Subject: RE: Stakers Farm

Please find amended plans addressing the concerns raised in our numerous correspondence. The key amendments are as follows:

Proposed North-West Elevation (A)

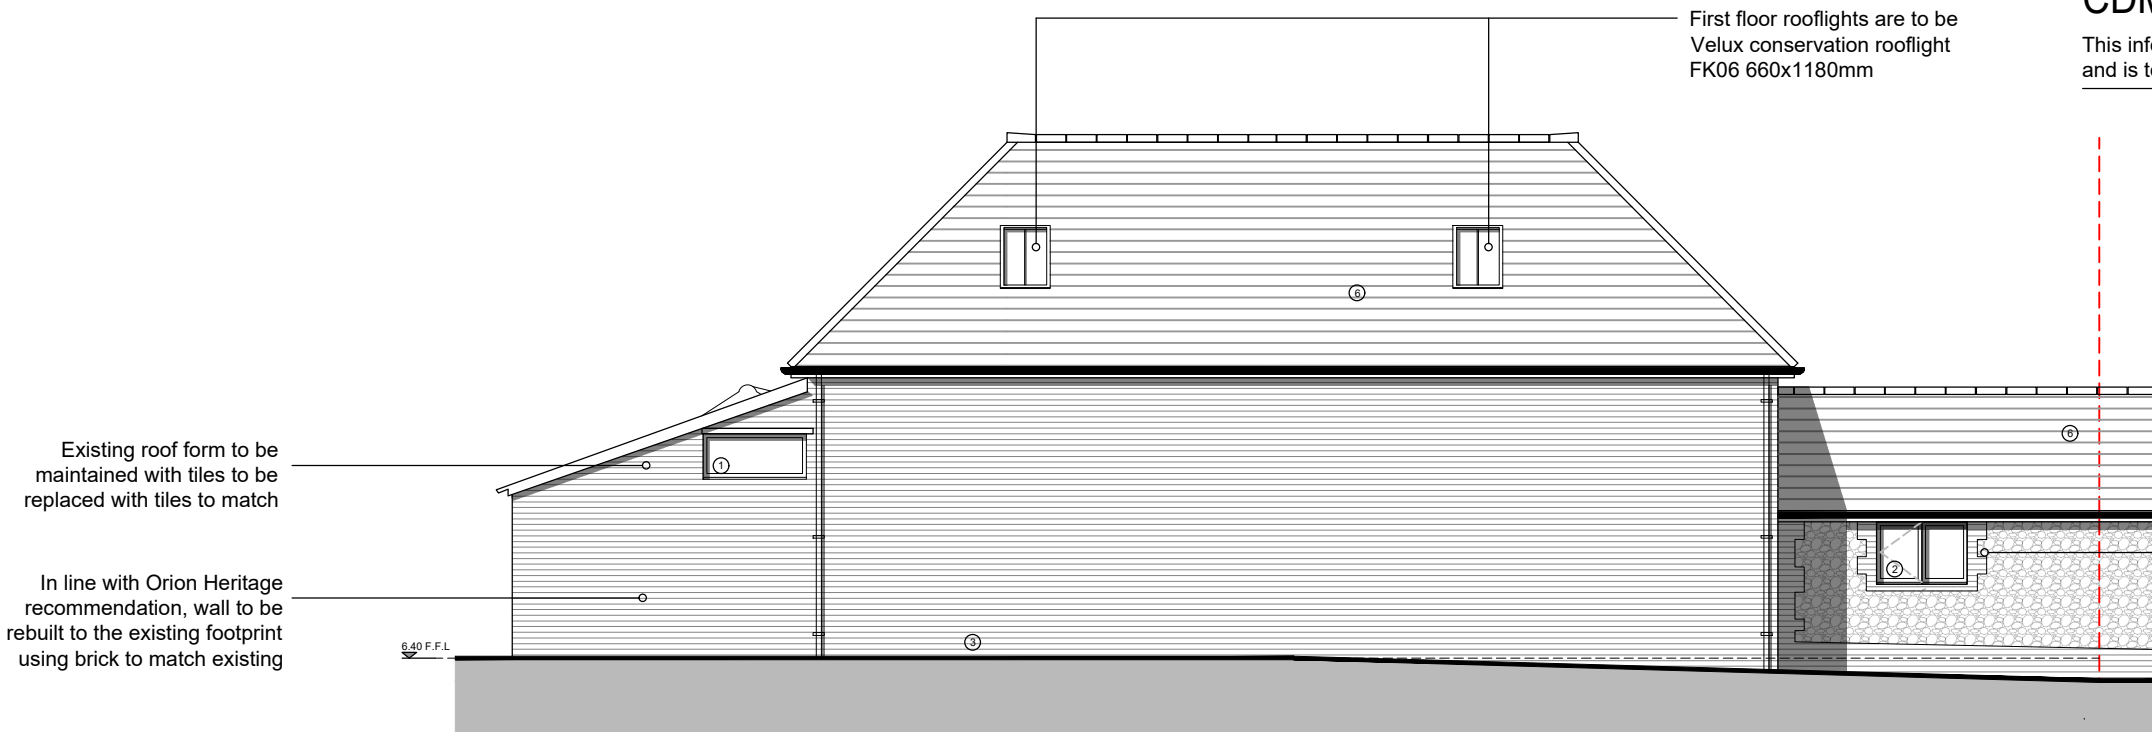
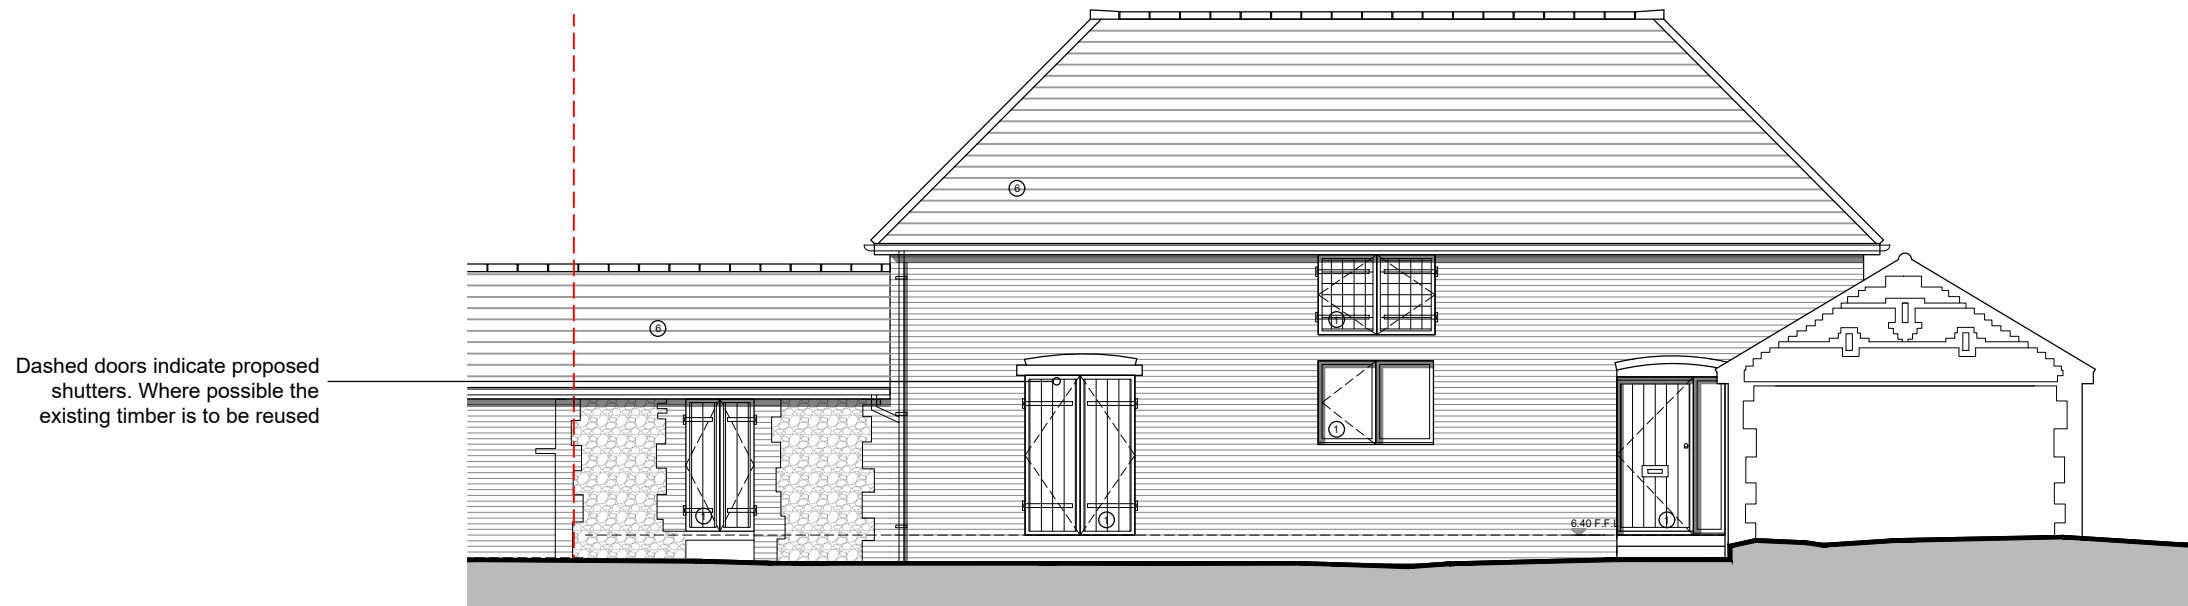
- Amount of conservation rooflights reduced to just two (one per bedroom) located on less prominent north western elevation.
- South elevation amended so size and position of new windows and doors reflect existing.

Proposed North West Elevation (A)

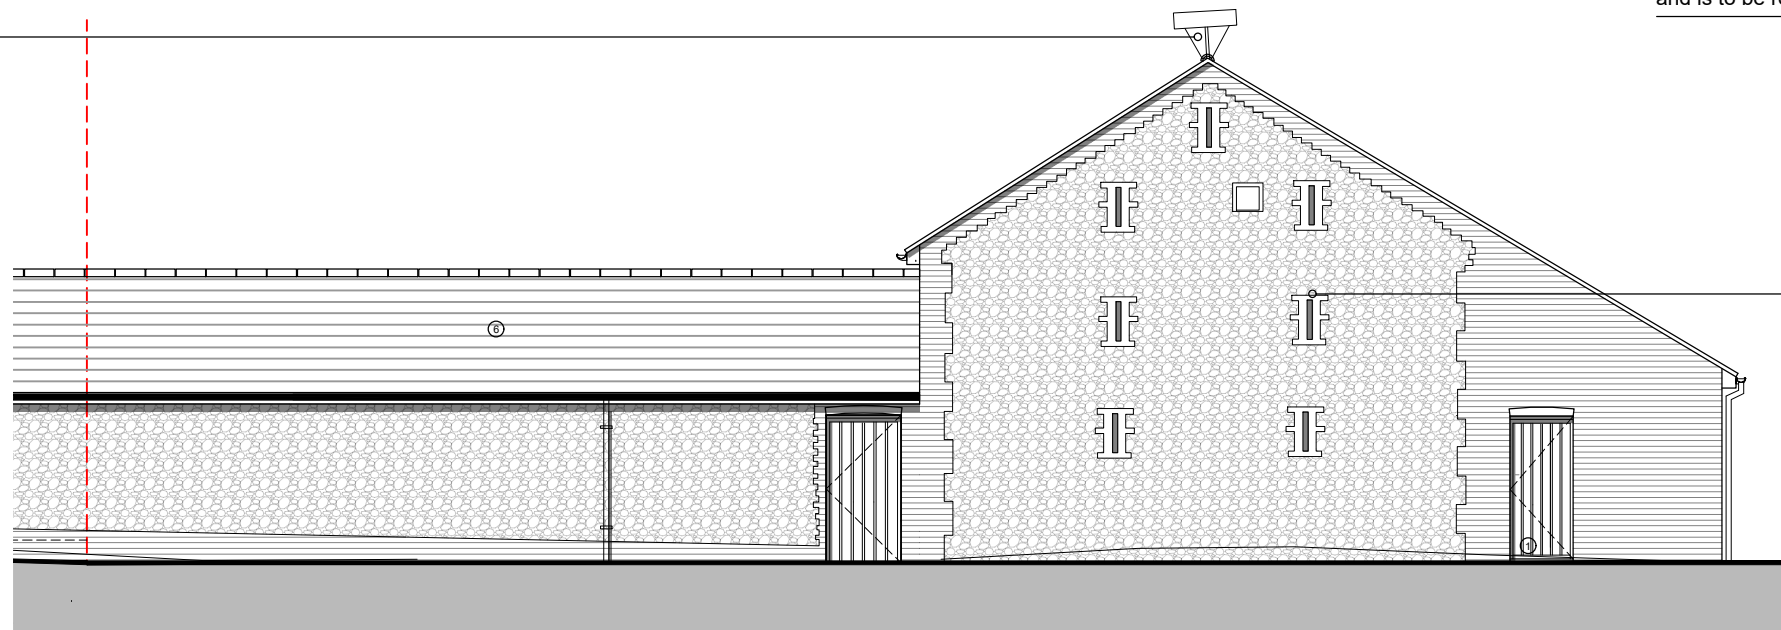
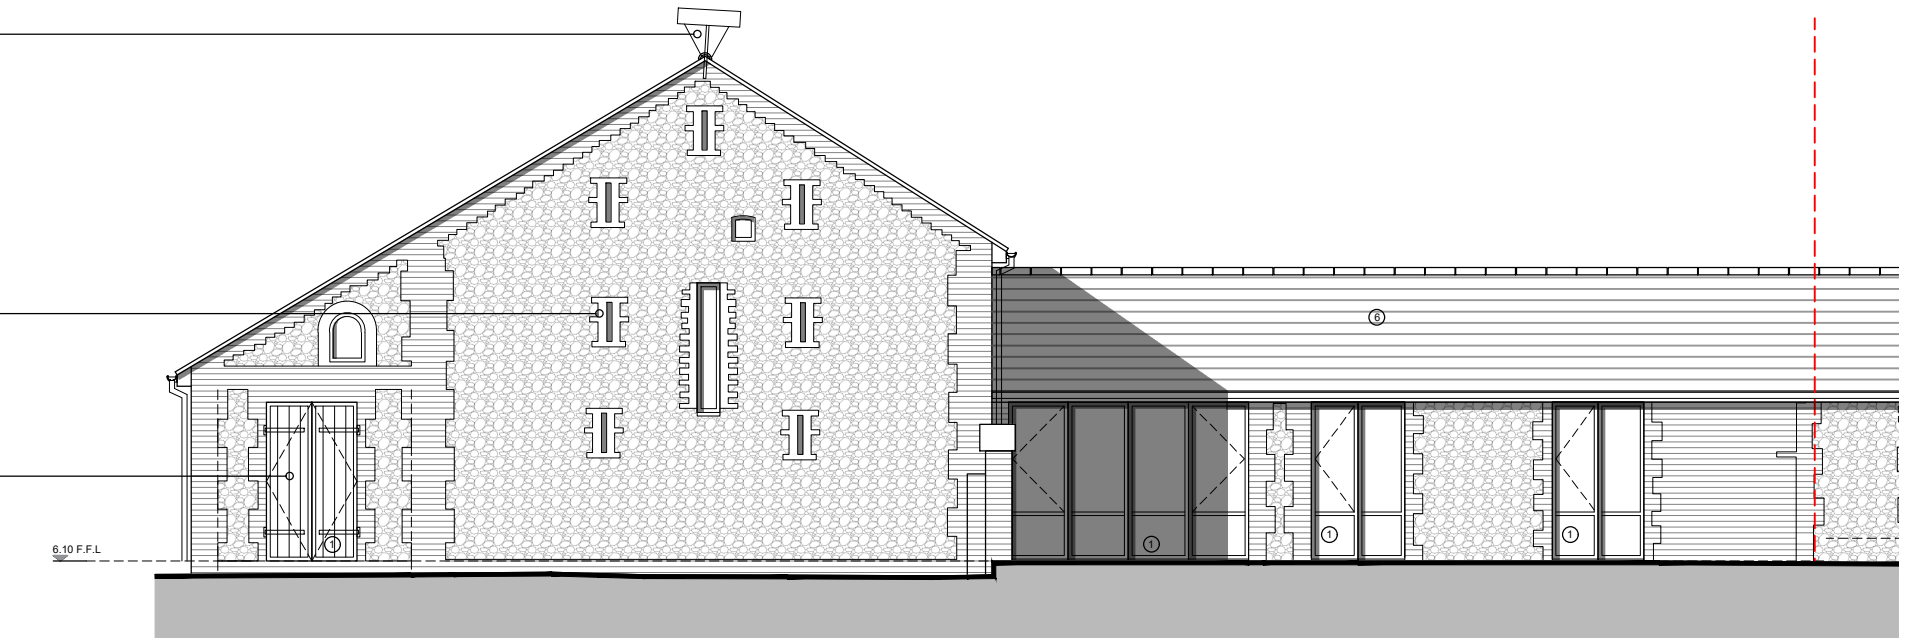
- Windows on east elevation of single storey element reflect the existing openings as closely as possible.
- South elevation – the size/number of doors on the south elevation have been reduced in size to reduce the impact as far as possible whilst allowing access to the courtyard.
- North elevation – the number of rooflights has been reduced as per our telephone conversation in early April.
